From: Amanda Scholes on behalf of Planning.Responses
Sent: 02 December 2019 09:12
To: Planning Scanning
Subject: FW: Littlehampton: CEMP Rev B - LU/339/19/DOC and LU/340/19/DOC

From: Steven Shaw [REDACTED]
Sent: 29 November 2019 15:13
To: Michael Eastham [REDACTED], Clark, Robert [REDACTED]
Cc: Bernadette Gledhill [REDACTED], Jamie Brown [REDACTED]
Subject: RE: Littlehampton: CEMP Rev B - LU/339/19/DOC and LU/340/19/DOC

ii. Traffic Routes Offsite

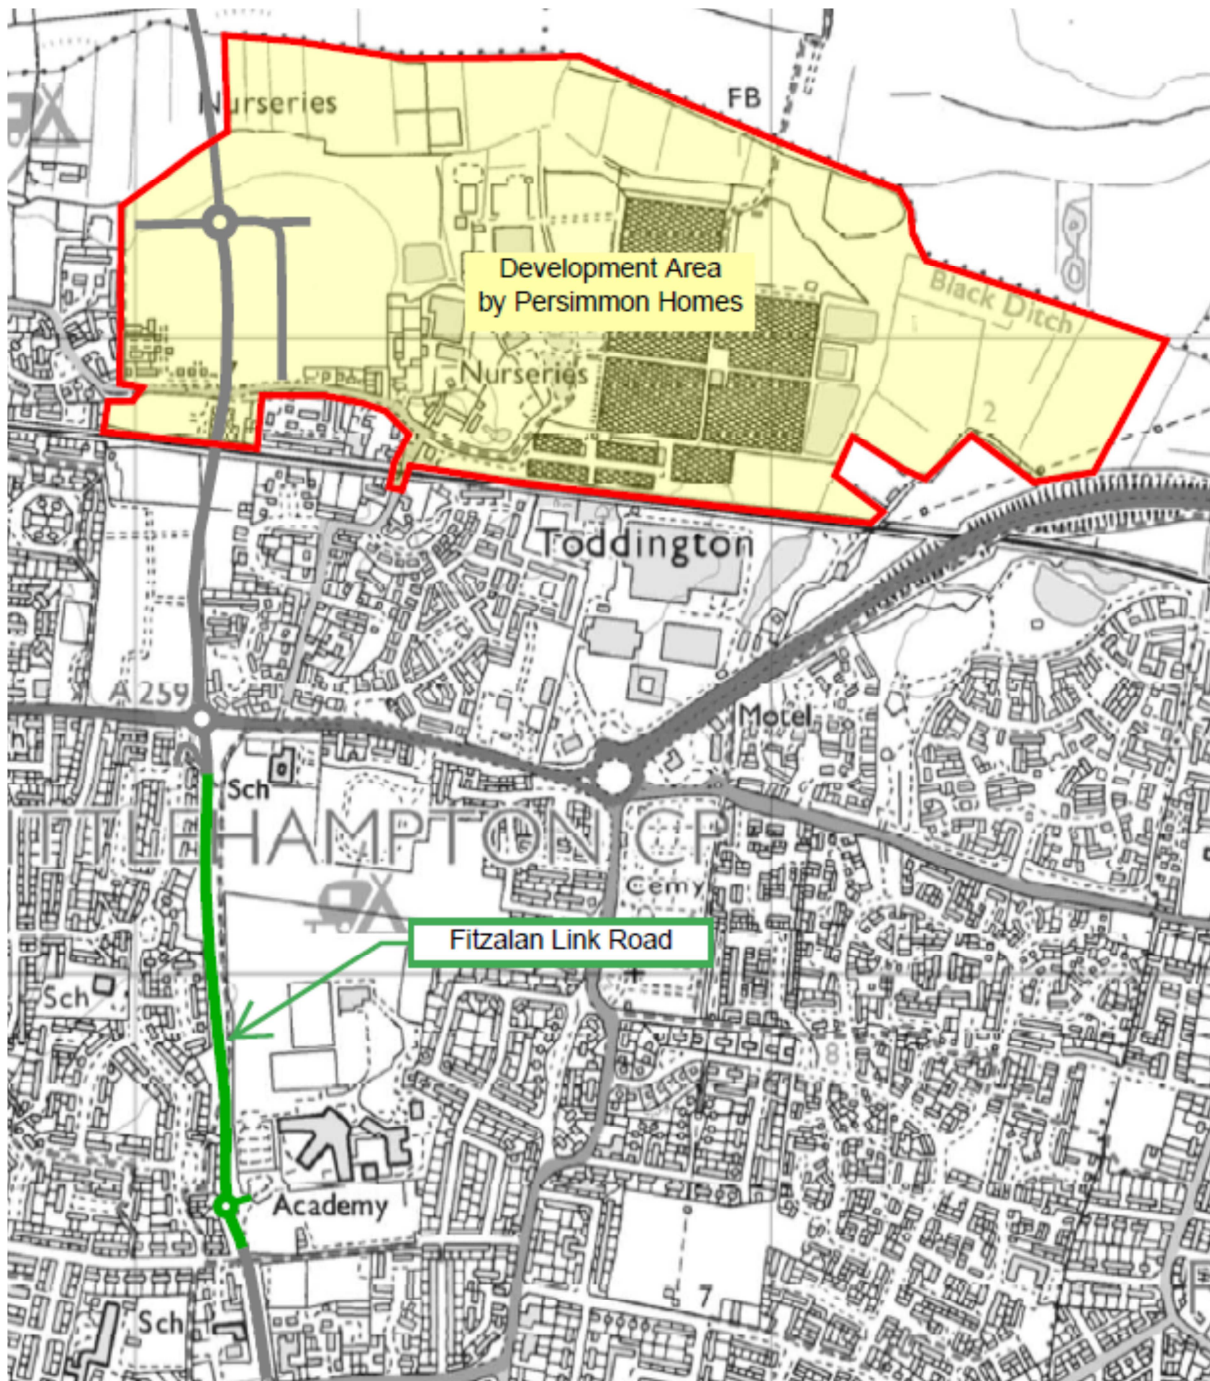
- There is no indication of where traffic will be entering from when they enter Richardson Way off Toddington Lane. We would look for the applicant to submit details of the proposed construction traffic routes from the A27 and that these be on the most appropriate routes as far as is practicle.

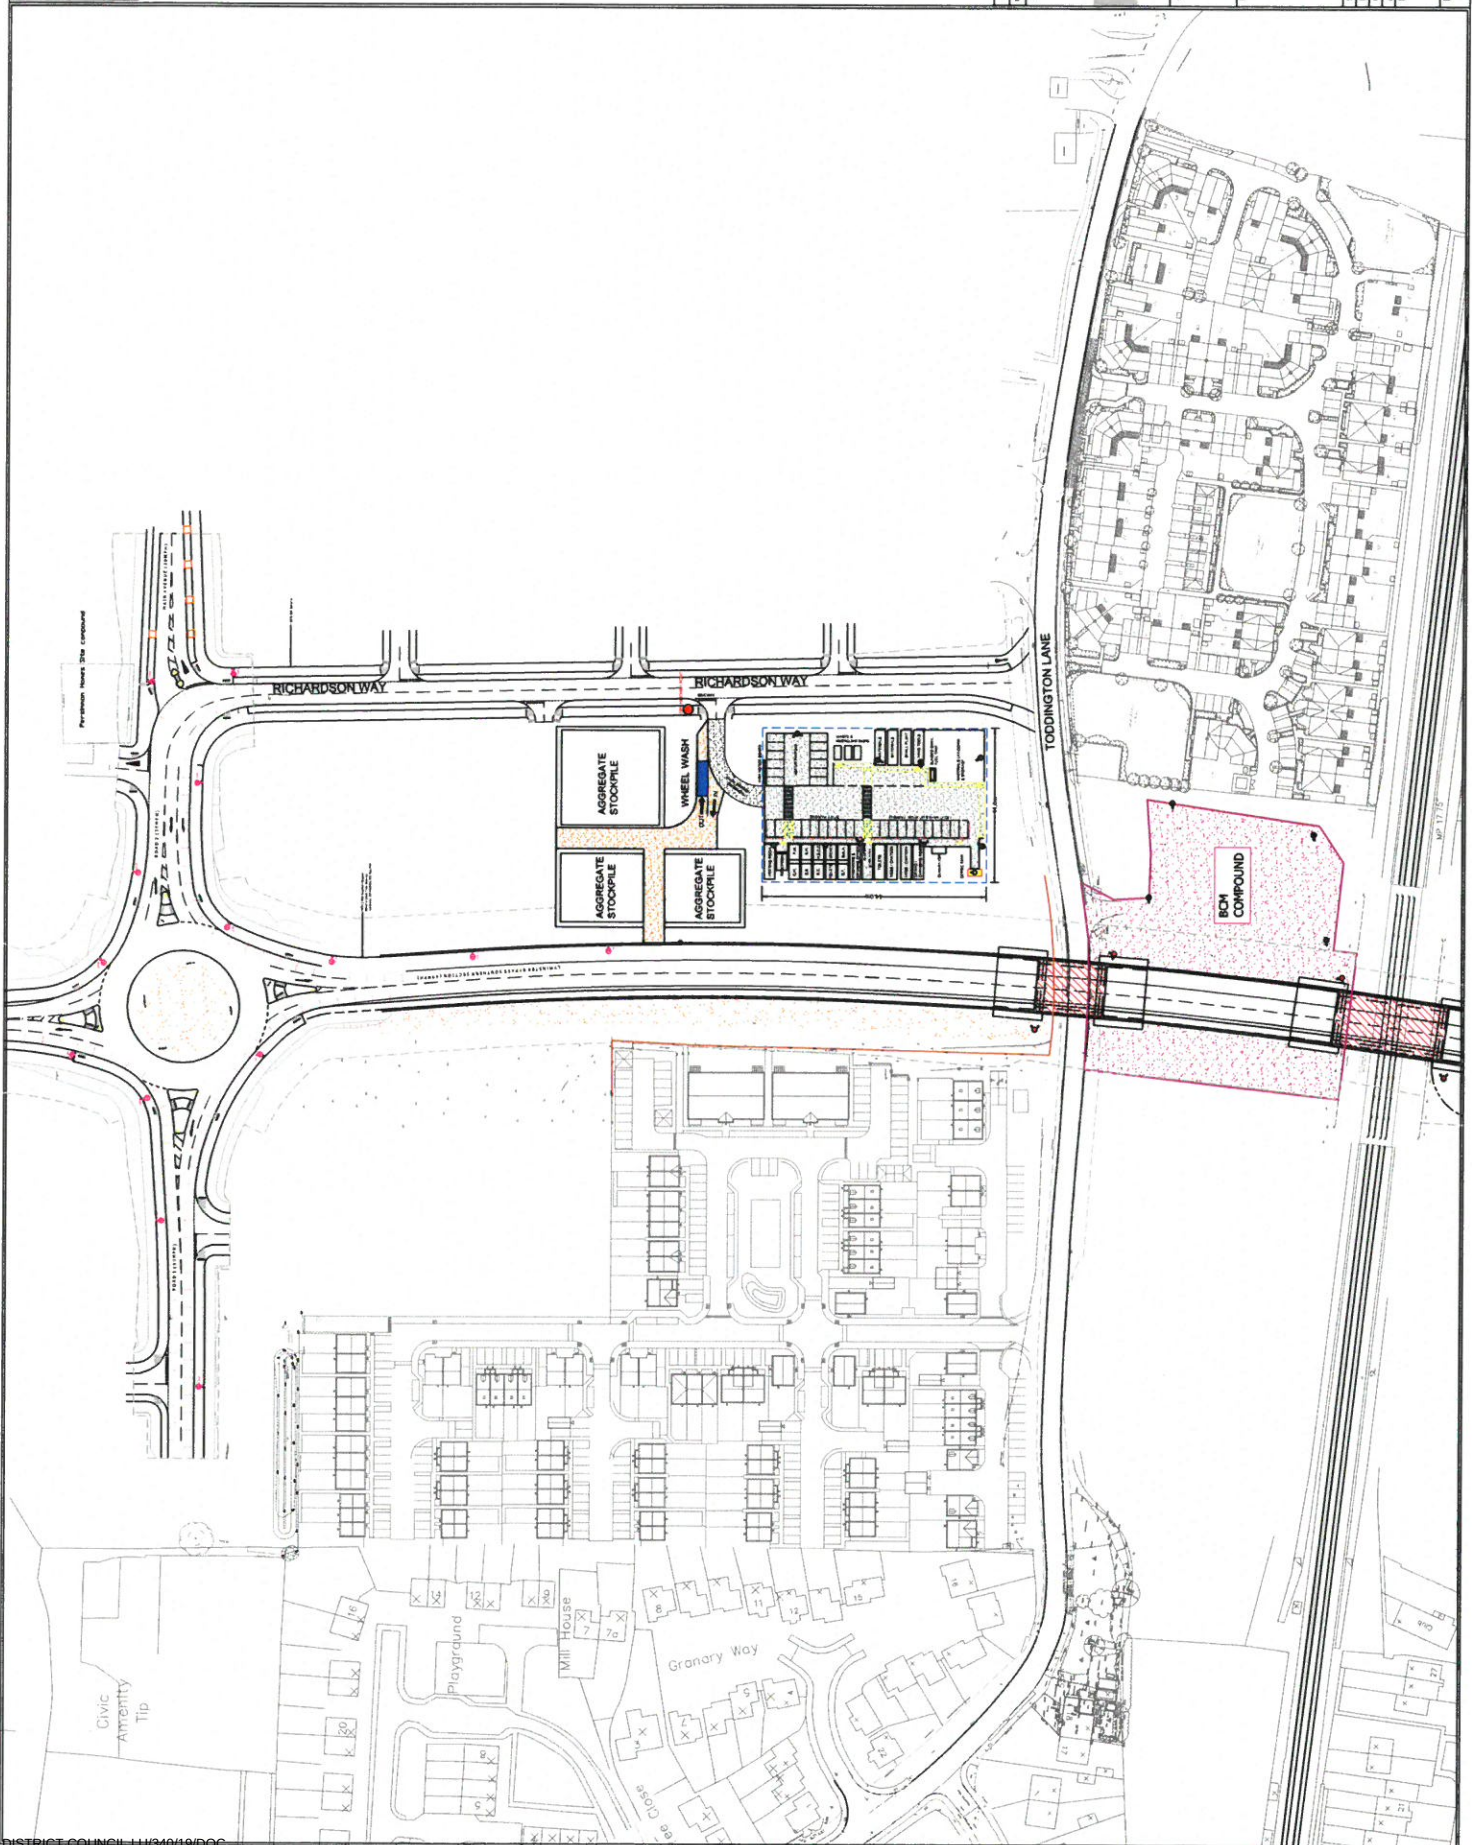
- Parking areas have not been demonstrated i.e not shown or laid out therefore difficult to know how much contractor parking could be housed. Clarification on the level of parking and its design and layout should be provided.

SITE DELIVERY POINTS.

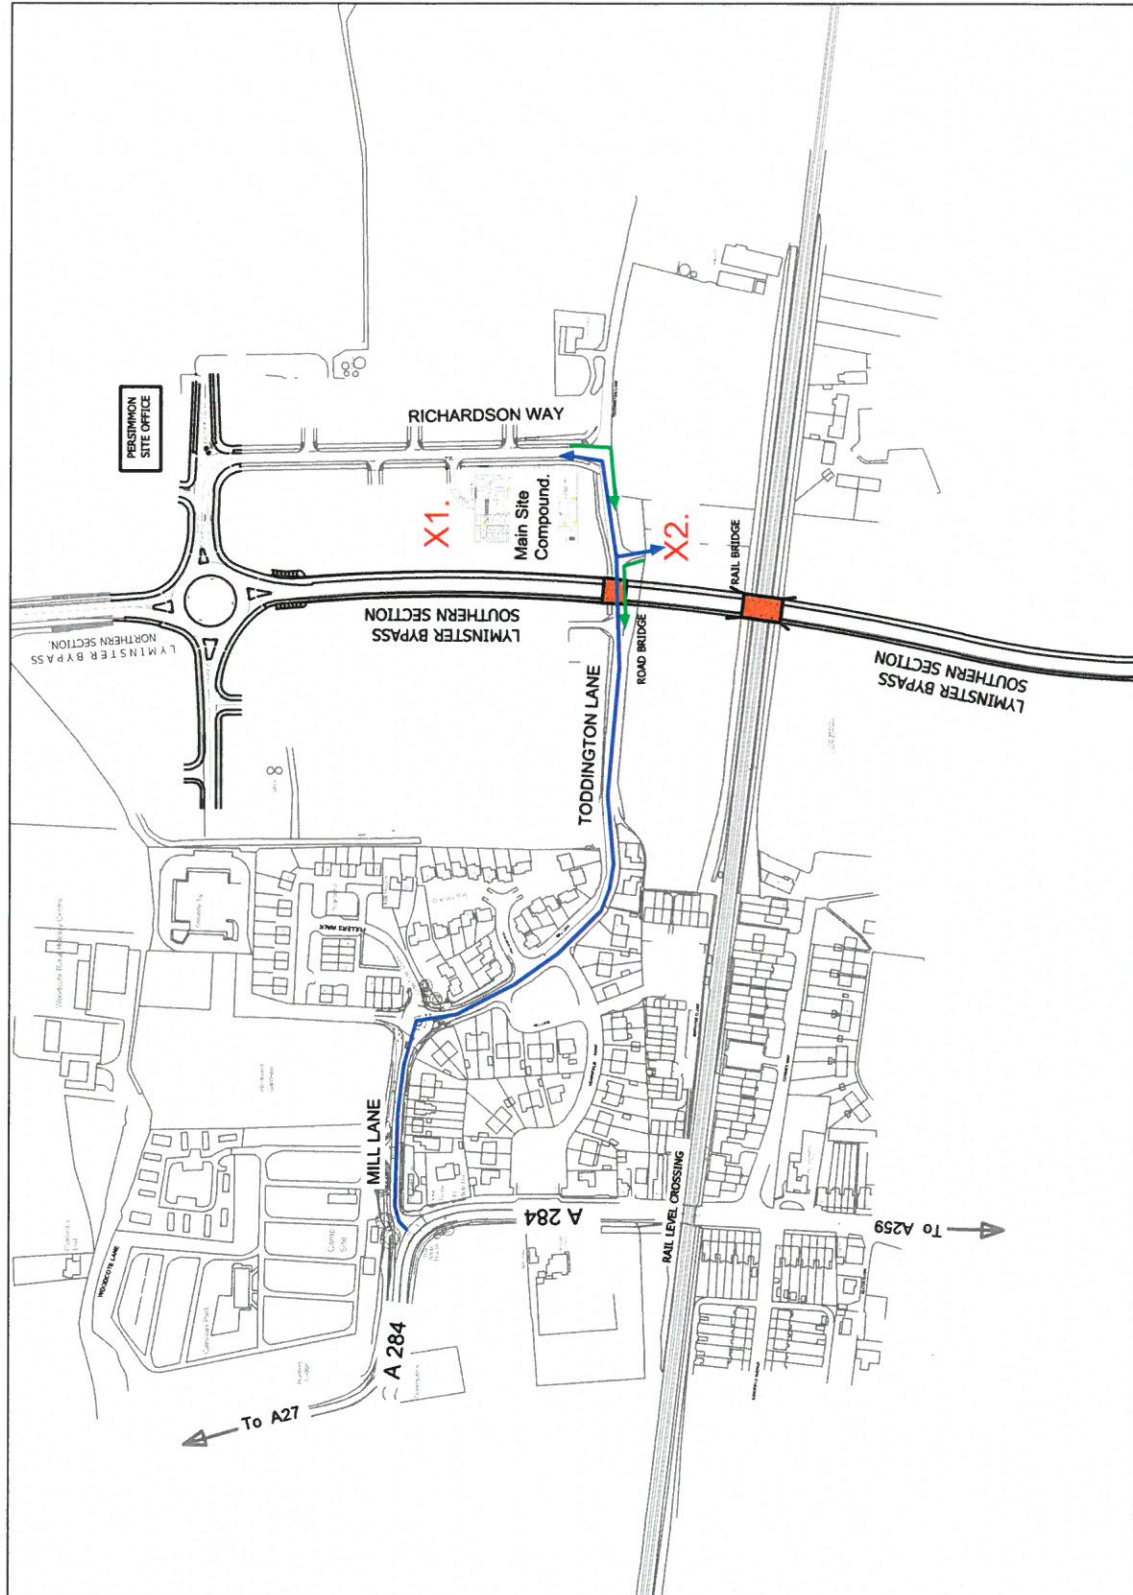
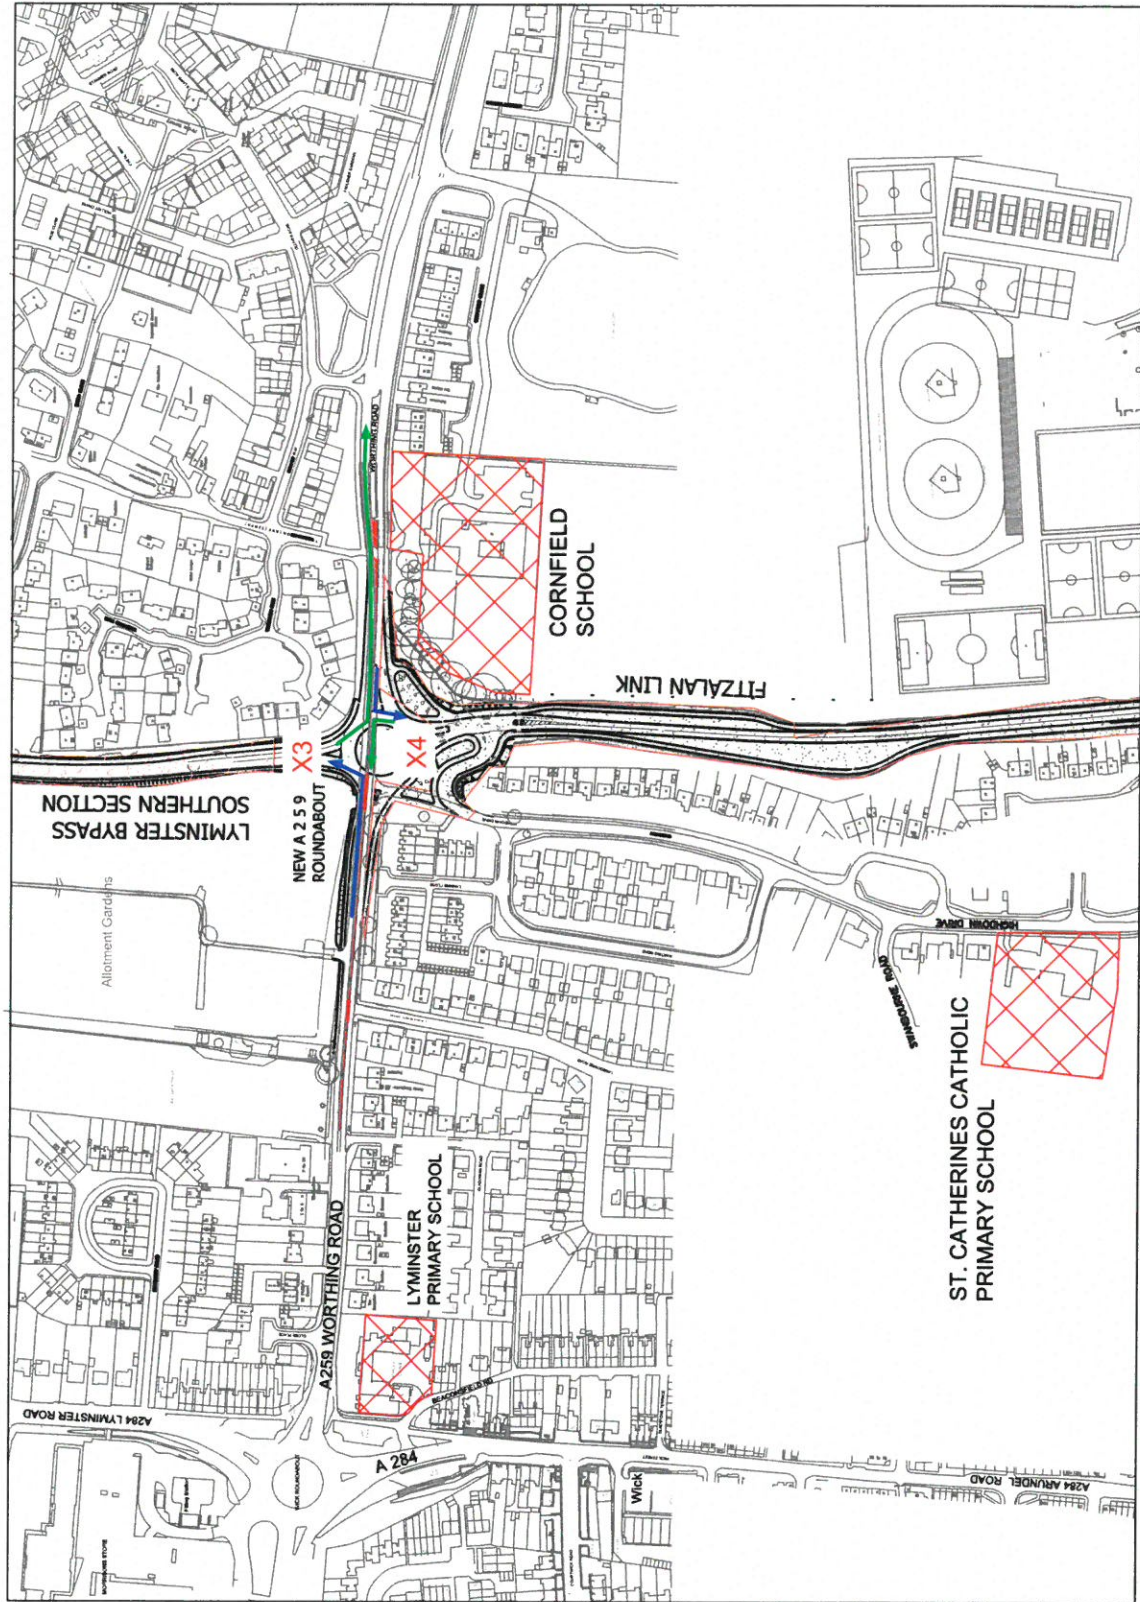
- Can the applicant confirm there will be no stacking on the highway during delivery times and that vehicles will load and un-load from within the site?
